**Consultation Response from Alan Smith,  
KC Waste Strategy (Refuse & Recycling)**

**2024/92848 Marsh Carpets, 82-84, Westbourne Road, Marsh, Huddersfield, HD1 4LF**

**Date Responded: 25/11/2025**

**Responding Ref: WPS 25 058**

Drawing
Proposed Floor Plans

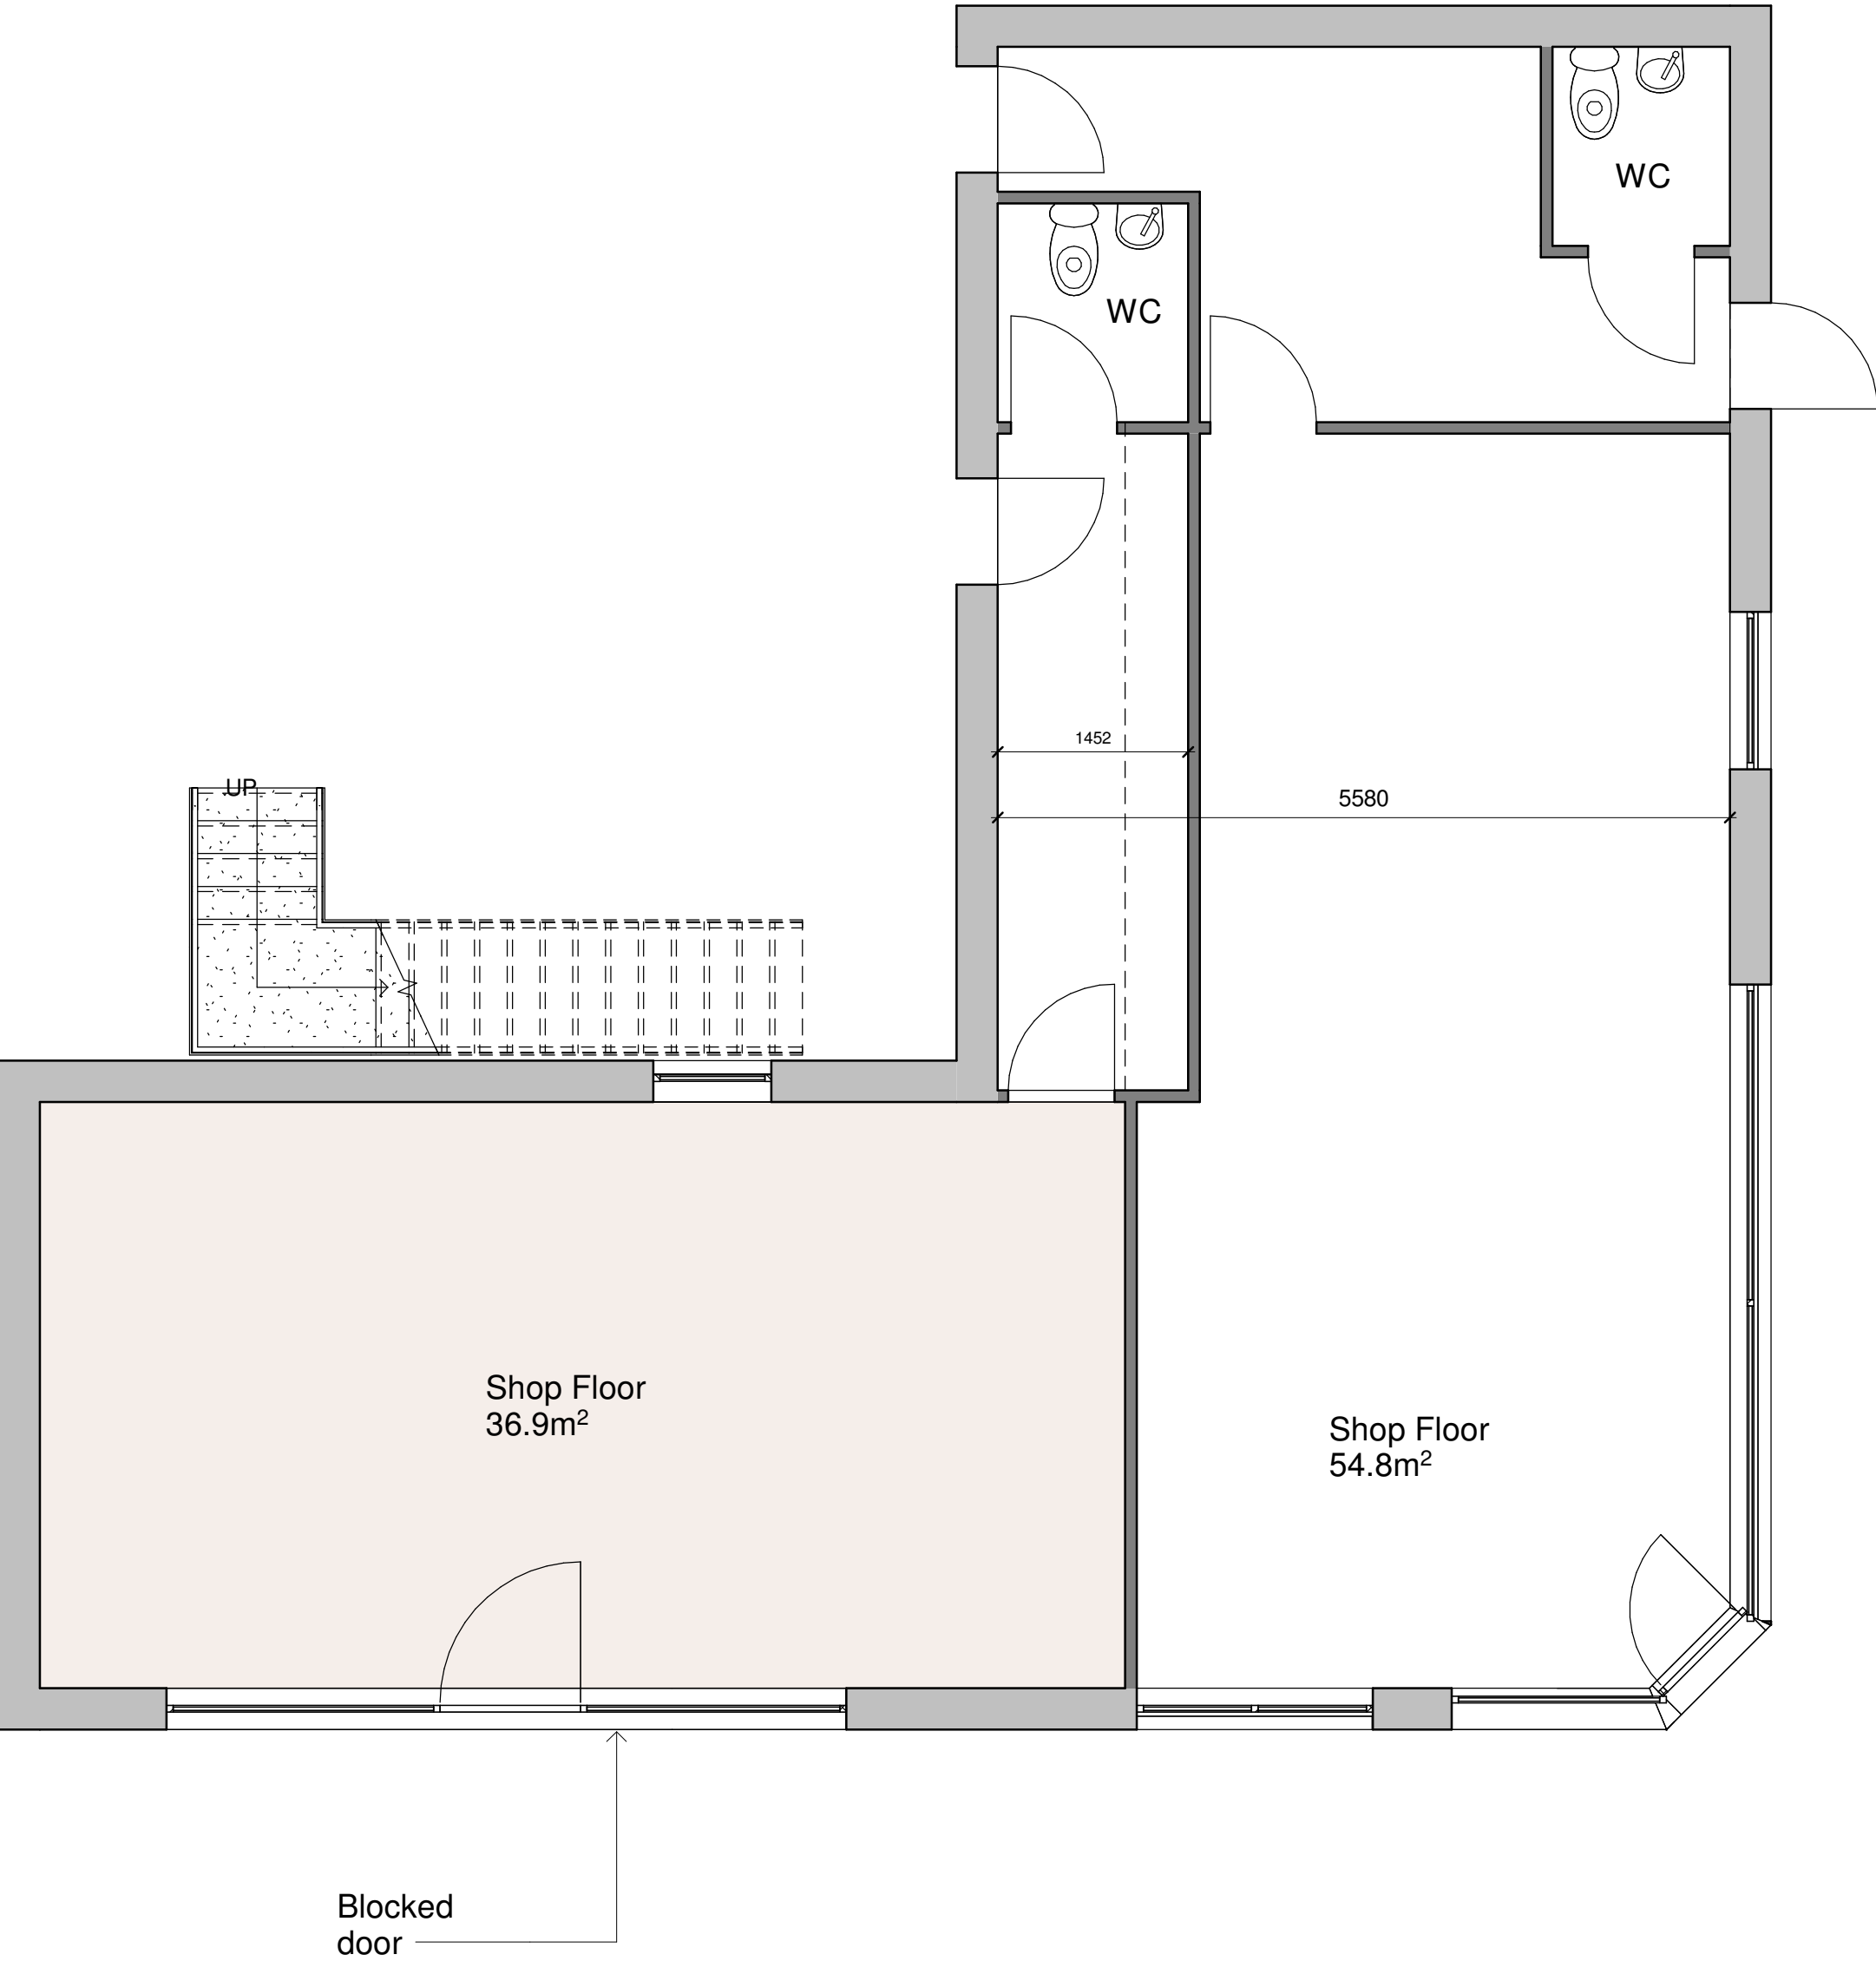
The drawing shows that 1 x 1,100L bin will be used for the commercial properties.

- The proposed bin store will be constructed of brick, which is fire resistant, this is an acceptable proposal
